BUILDING PERMIT REPORT

DATE: 7 DEC. 99. ADDRESS: 309 Spring ST. CBL: 061-C-013
REASON FOR PERMIT: Replacement of stairs to landing at rear door
BUILDING OWNER: Julie Evans
PERMIT APPLICANT: CONTRACTOR Keith Evans
USE GROUP: R-3 CONSTRUCTION TYPE: 5B CONSTRUCTION COST: \$350.00 PERMIT FEES: \$30.00

PLAN EXISTING CONDITIONS REAR PORCH

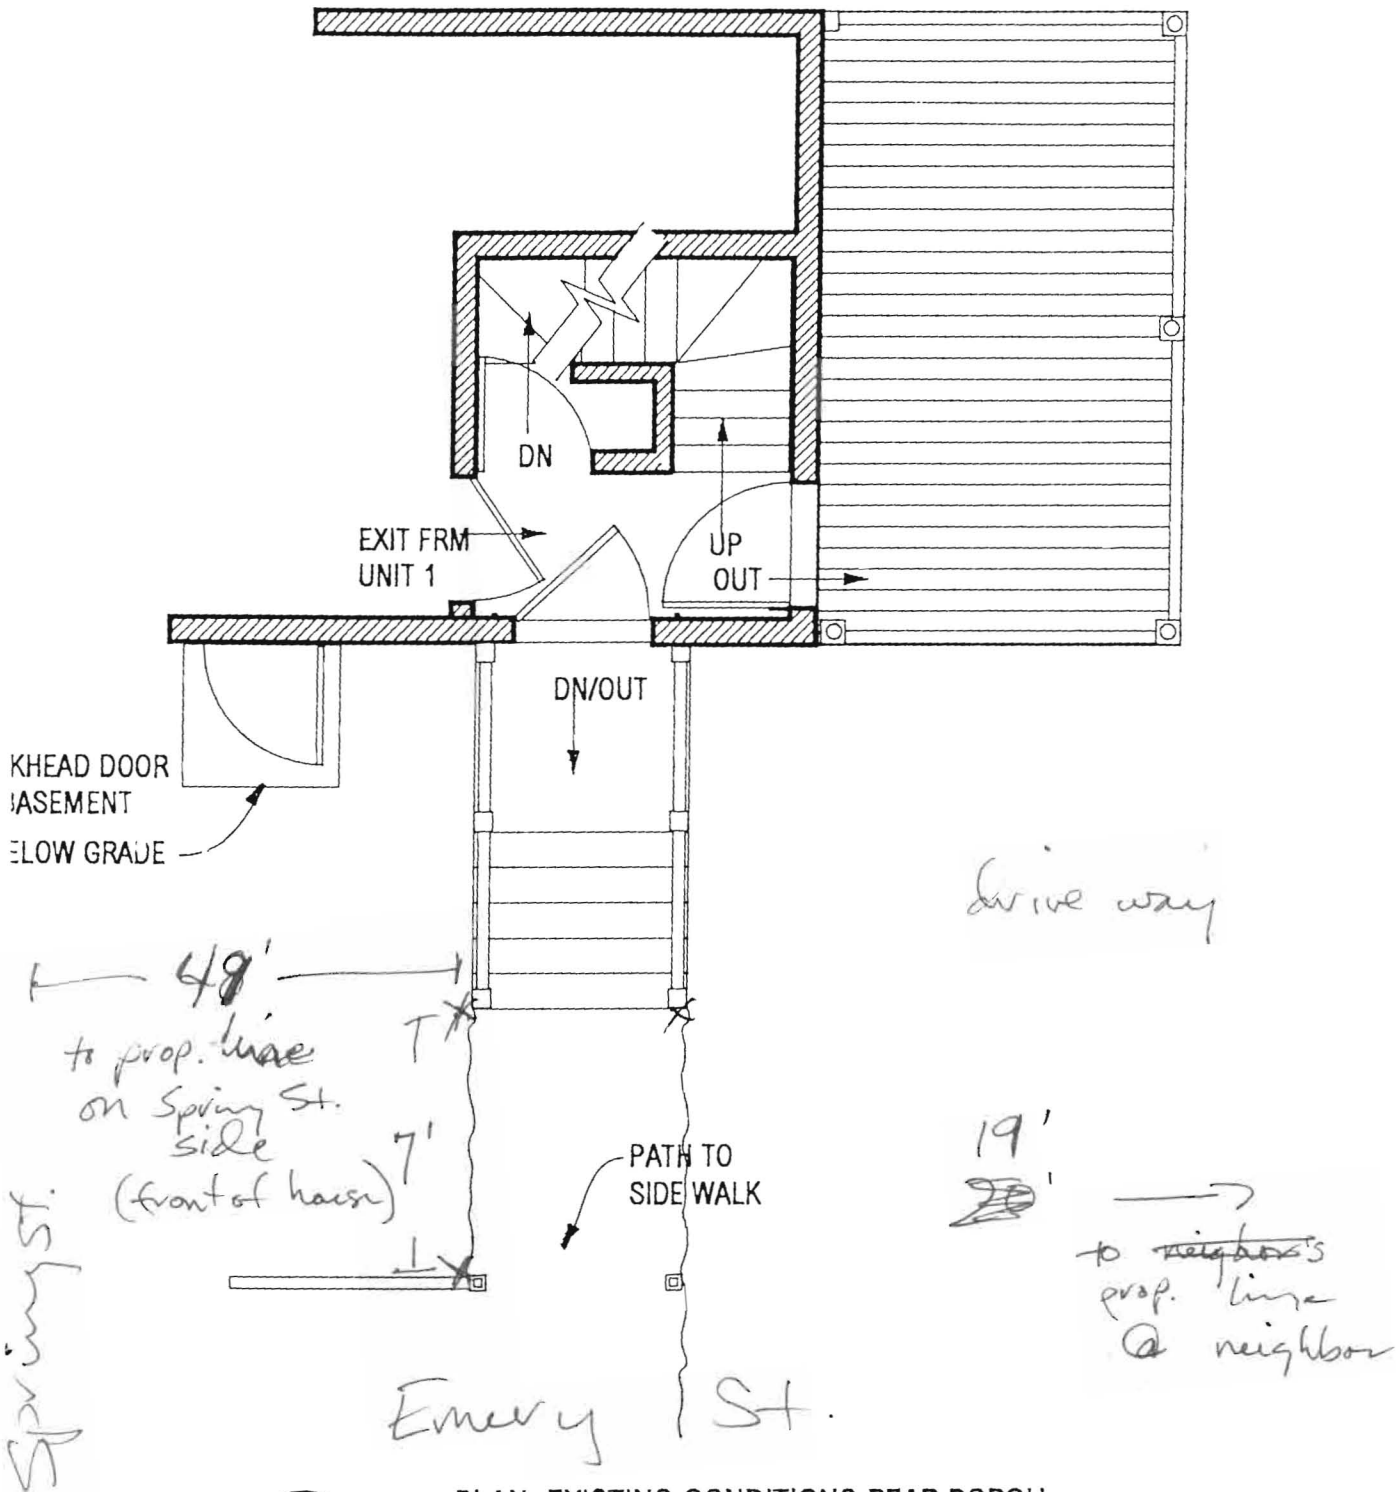
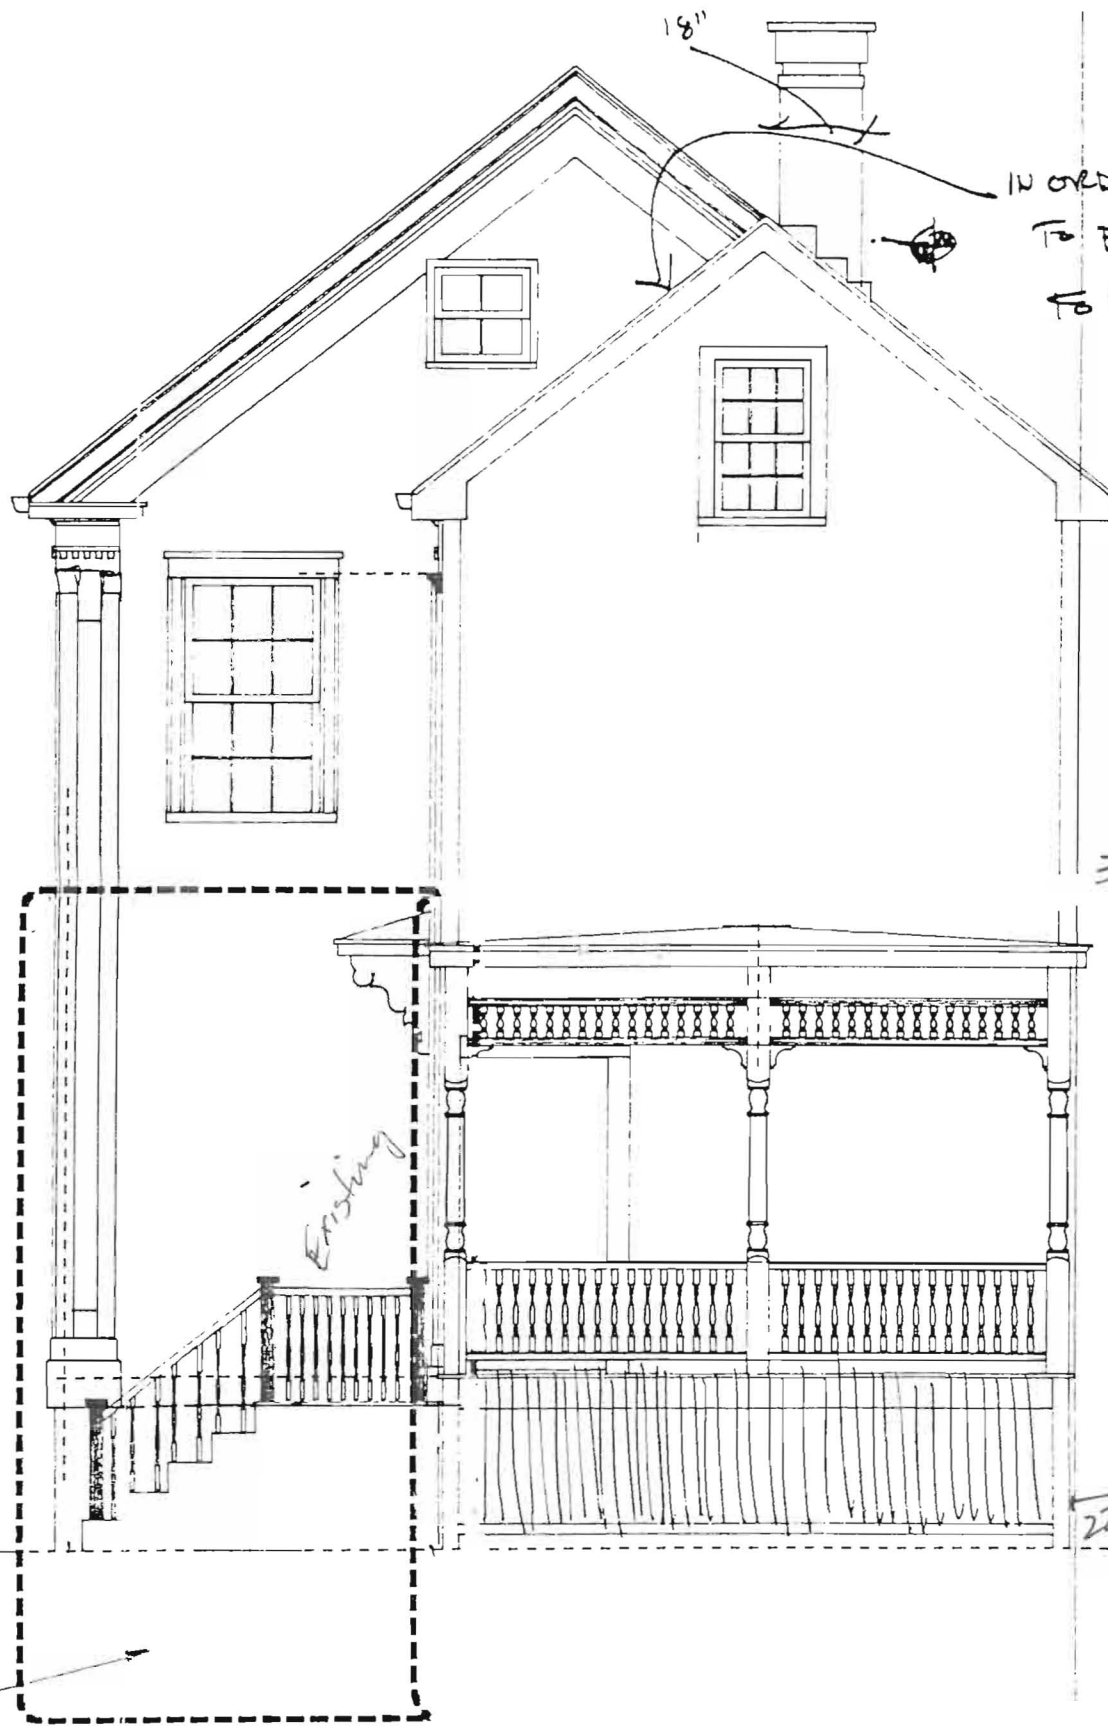
04/05/00 - STAIRS finished and IAW permit - heads & risers OK. Jmr
Close

This permit is being issued with the understanding that the following conditions are met: *1, *11, *13, *34

- X 10. Sound transmission control in residential building shall be done in accordance with Chapter 12, Section 1214.0 of the City's Building Code.
- X 11. Guardrails & Handrails: A guardrail system is a system of building components located near the open sides of elevated walking surfaces for the purpose of minimizing the possibility of an accidental fall from the walking surface to the lower level. Minimum height all Use Groups 42", except Use Group R which is 36". In occupancies in Use Group A,B,H-4, I-1, I-2, M and R and public garages and open parking structures, open guards shall have balusters or be of solid material such that a sphere with a diameter of 4" cannot pass through any opening. Guards shall not have an ornamental pattern that would provide a ladder effect. (Handrails shall be a minimum of 34" but not more than 38". Use Group R-3 shall not be less than 30", but not more than 38"). Handrail grip size shall have a circular cross section with an outside diameter of at least 1 1/4" and not greater than 2". (Sections 1021 & 1022.0). Handrails shall be on both sides of stairway. (Section 1014.7)

- X 12. Headroom in habitable space is a minimum of 7'6". (Section 1204.0)
- X 13. Stair construction in Use Group R-3 & R-4 is a minimum of 10" tread and 7 3/4" maximum rise. All other Use Group minimum 11" tread, 7" maximum rise. (Section 1014.0)
